From: Anita Gardner
Sent: 11 December 2018 16:56
To: Planning.Responses
Subject: FW: ST MARYS CLOSE 2 DWELLINGS HURST ROAD; Surface Water Drainage

Please add to application R/190/18/PL

From: [REDACTED]
Sent: 11 December 2018 15:48
To: Laura Gibbons
Cc: [REDACTED]
Subject: ST MARYS CLOSE 2 DWELLINGS HURST ROAD; Surface Water Drainage

Development shall not commence, other than works of site survey and investigation, until full details of the proposed surface water drainage scheme have been submitted to and approved in writing by the Local Planning Authority. The design should follow the hierarchy of preference for different types of surface water drainage disposal systems as set out in Approved Document H of the Building Regulations, and the recommendations of the SuDS Manual produced by CIRIA. Winter Percolation testing to BRE 365, or similar approved, will be required to support the design of any infiltration drainage. No building / No part of the extended building shall be occupied until the complete surface water drainage system serving the property has been implemented in accordance with the agreed details and the details so agreed shall be maintained in good working order in

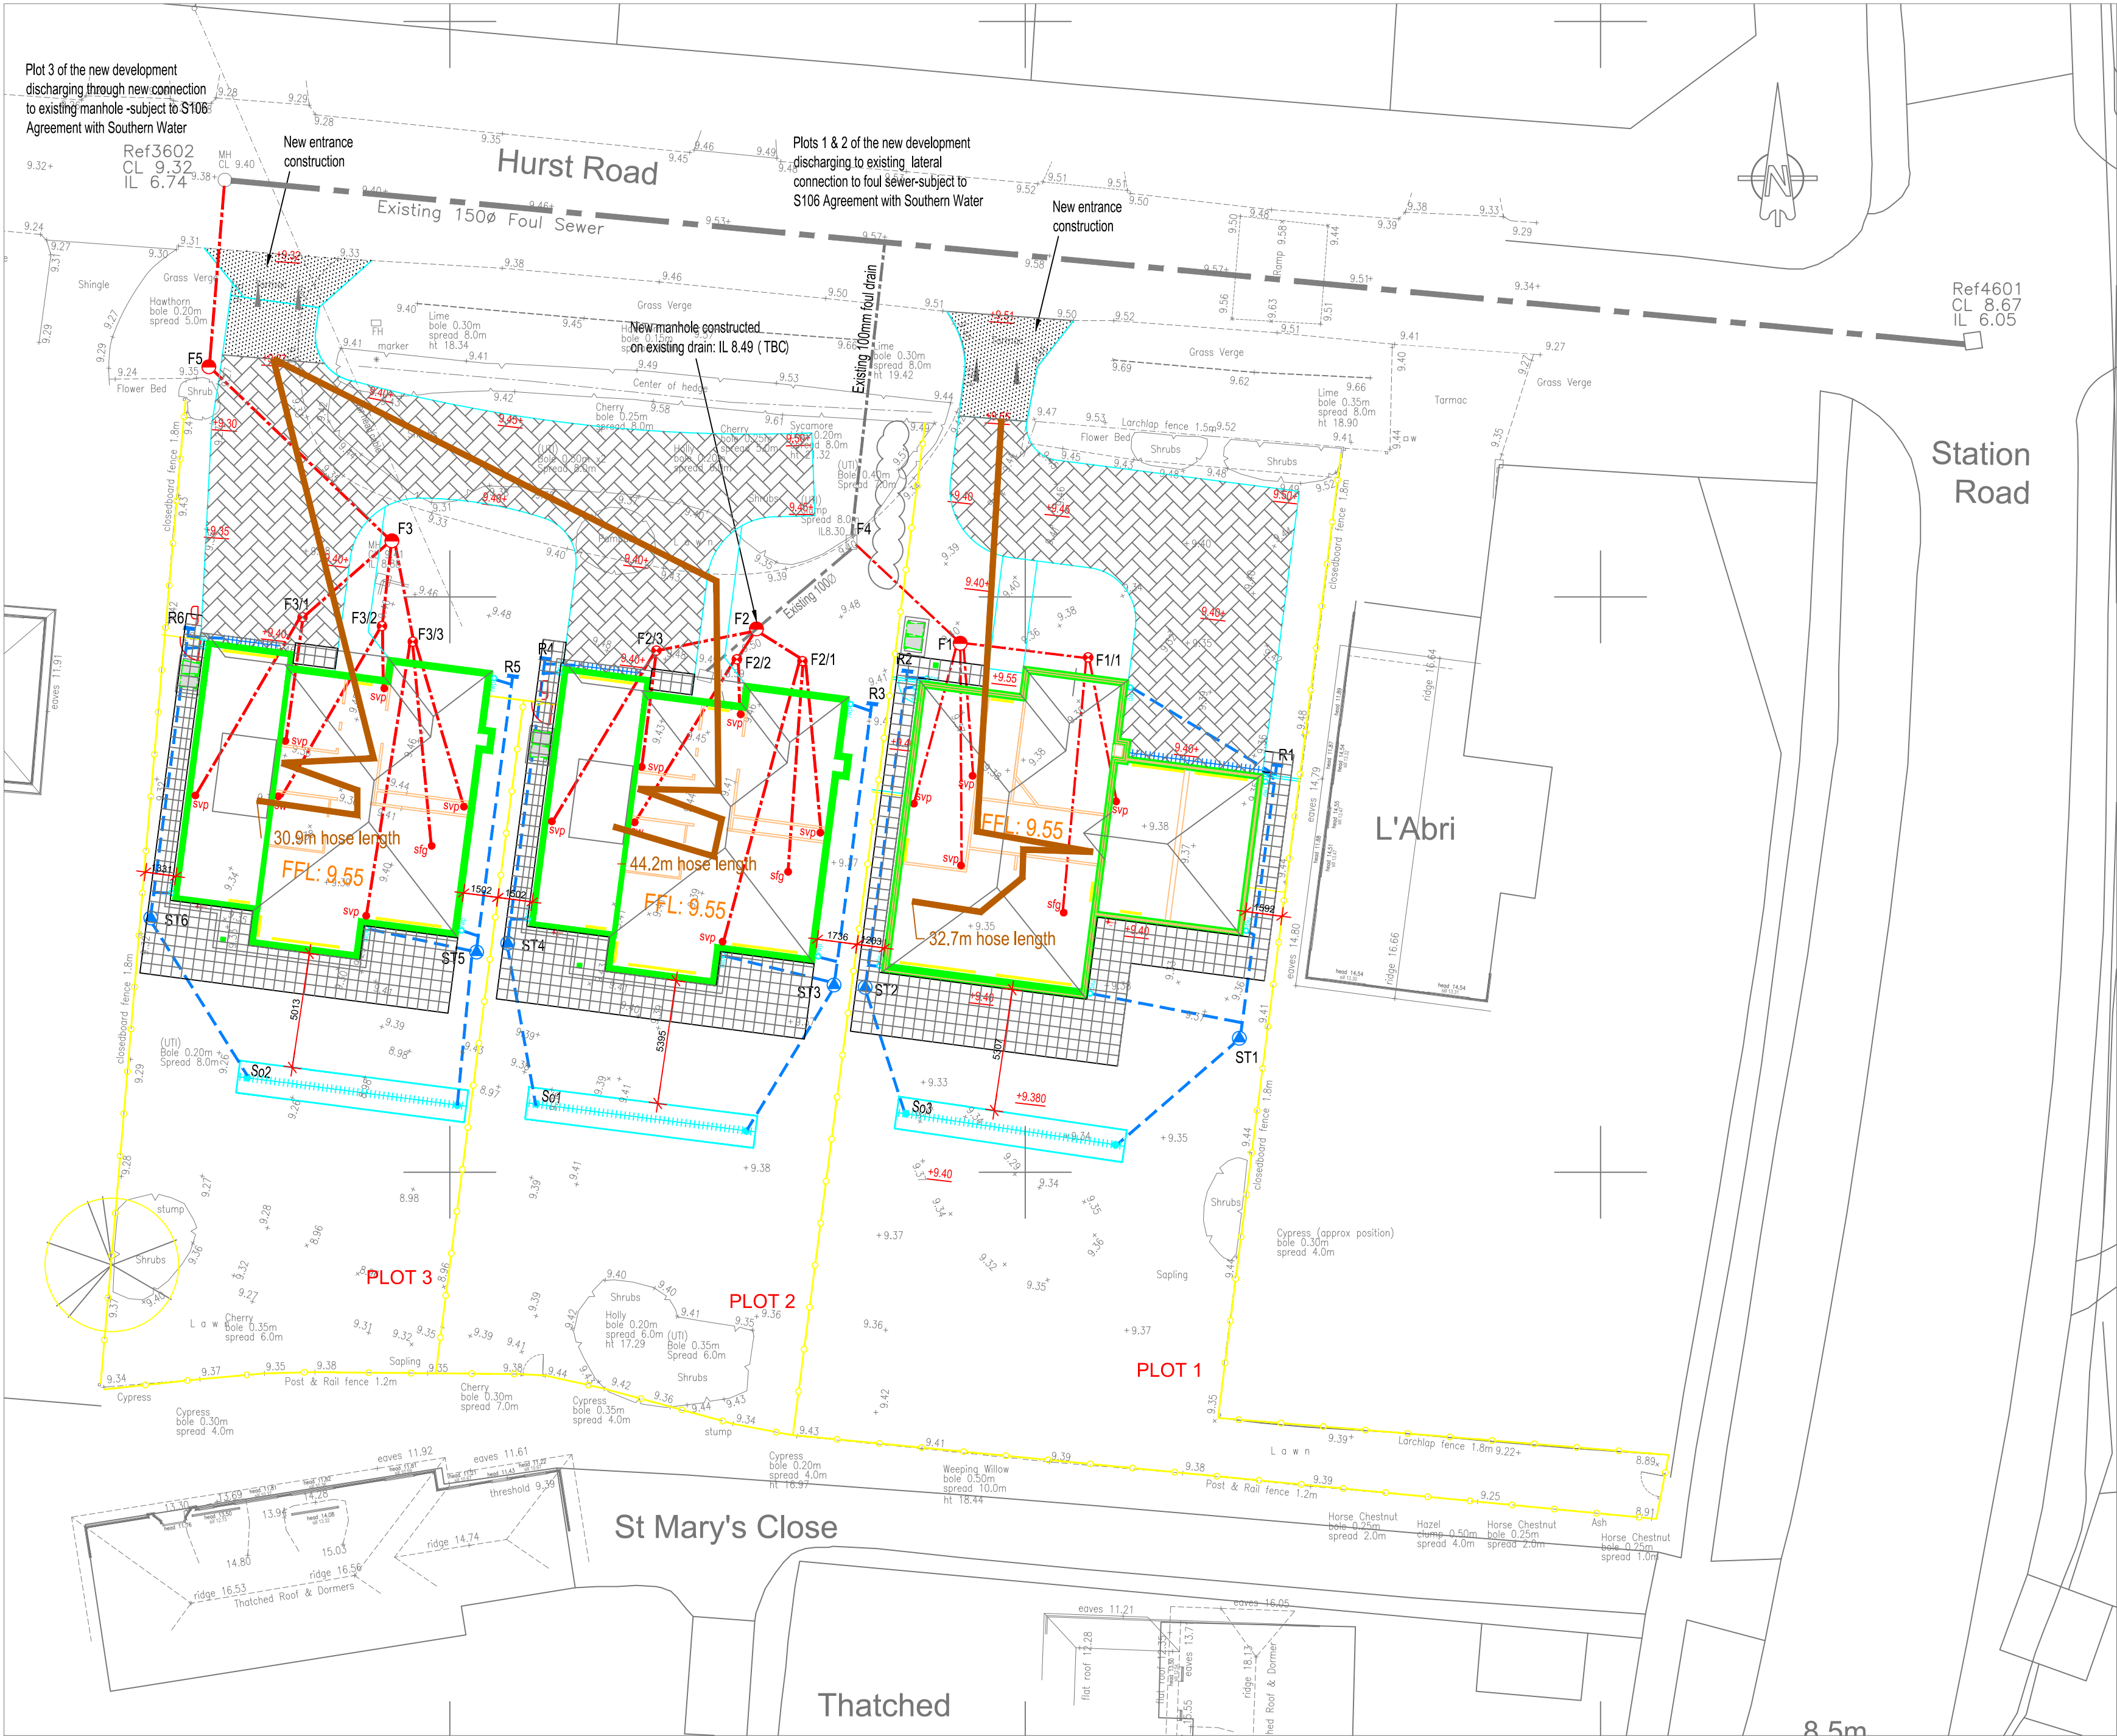
This is the information I saw previously prior to my original consultation response. Where I stated that infiltration tests must be completed in the winter, at depths less than 2.2m bgl. These tests should be compliant with BRE365.

The condition is still required in my opinion as winter infiltration tests haven't been completed.

It is not clear from the supplied if further infiltration testing was completed at the appropriate time of year and depth or not.

I will need construction details supplied too.

We have been working with MJH Homes on the engineering aspects of this scheme but have only just been made aware of responses from your Authority on the drainage aspects. It appears that you were not supplied with the winter ground monitoring results that were undertaken earlier in the year.

So for your information please find attached a copy of the monitoring results undertaken between February and April this year.
